STATE OF NORTH CAROLINA
DEPARTMENT OF TRANSPORTATION

July 5, 2017

SUBJECT: **Addendum to the Application for Section 404 Individual Permit and Section 401 Water Quality Certification** for the proposed I-26 Interchange improvements at NC 191 (Brevard Road), Buncombe County, Division 13; Federal Aid Project No. IMF-26-1(191)47; TIP Project No. I-5504.

SITE 1C / 1D ENLARGEMENT

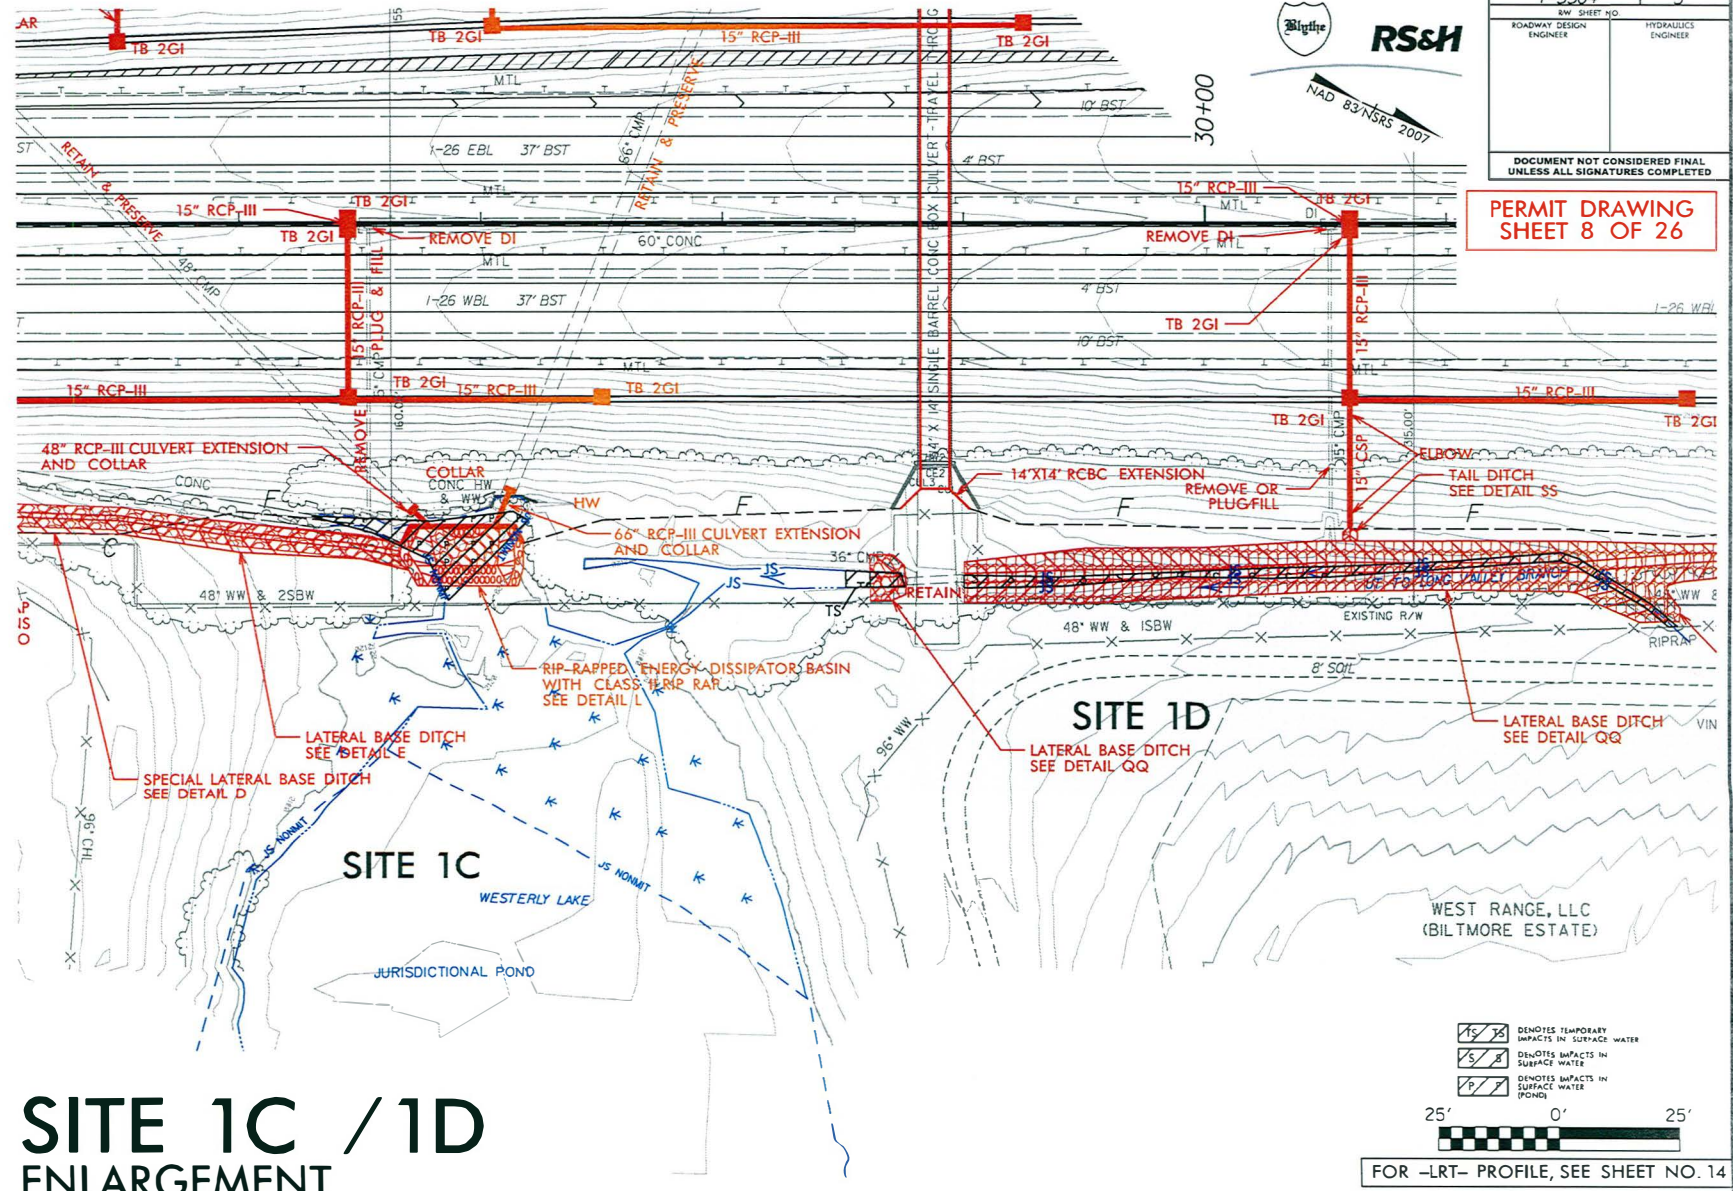
Site 1d – UT to Long Valley Branch

A 15” Corrugated Metal Pipe (CMP) is being plugged and filled, and a new 15” Reinforced Concrete Pipe (RCP) / Corrugated Steel Pipe (CSP) is being installed at this site to assist in proper roadway stormwater drainage. The new pipe will outlet adjacent to a UT to Long Valley Branch/Westerly Lake (Stream SI).

Stream SI paralleling the Biltmore Estate fence will be lined with rip rap for 313 linear feet to address erosion and sediment concerns expressed by West Range through the Section 404 public comment process. In addition, a rip rap ditch has been extended above Stream SI, paralleling the proposed toe of slope of I-26, to further minimize sedimentation from overland flow in this area and to contain the stormwater runoff, keeping it on NCDOT property.
